<b>Consultation Response from KC, Trees</b>
<b>2024/91591 Land off, Bankwood Way, Birstall Retail Park, Birstall, Batley, WF17 9DT</b>
<b>Variation conditions 2-6, 15, 29 on previous permission 2021/92528 for erection of retail development, associated parking, servicing areas and landscaping</b>
<b>Date Responded: 29/11/2024 Responding Officer: JD Responding Ref:</b>

Drawing no: R/2459/1P

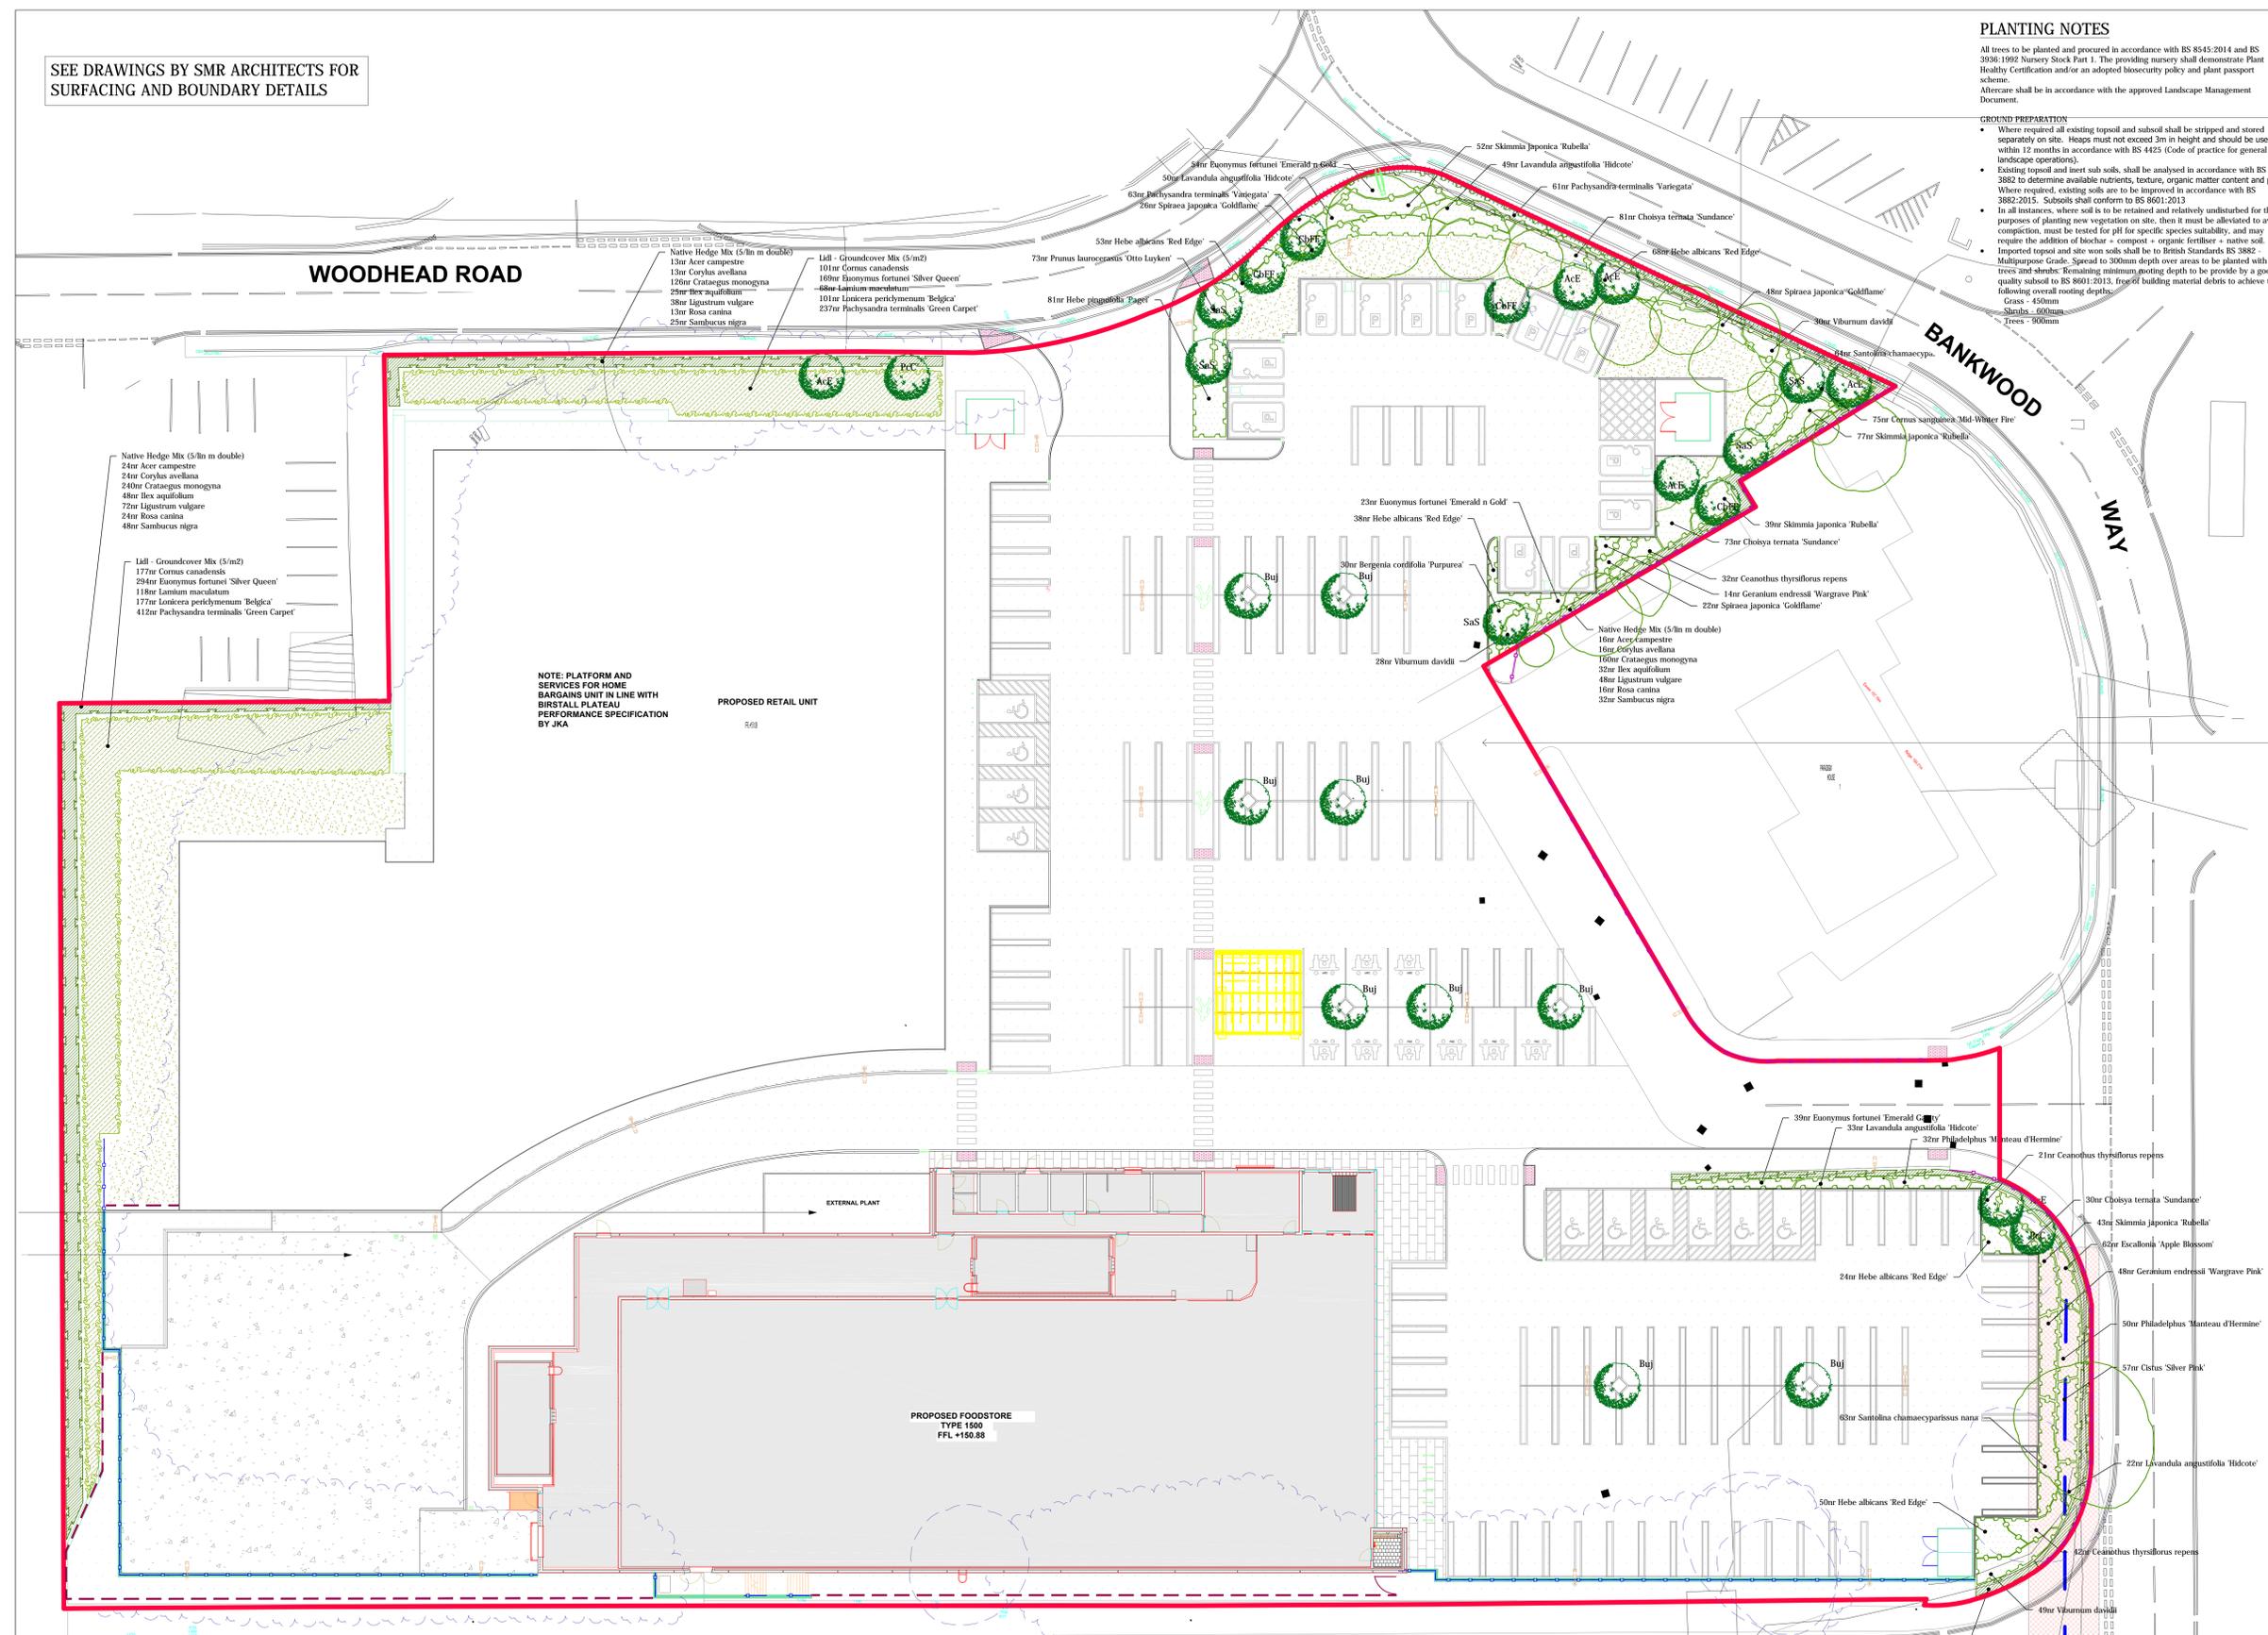
The revised landscaping scheme sufficiently shows all retained trees and new planting to take place and the tree section is satisfied that this outcome sufficiently mitigates any trees lost.

No further comments and no objection.
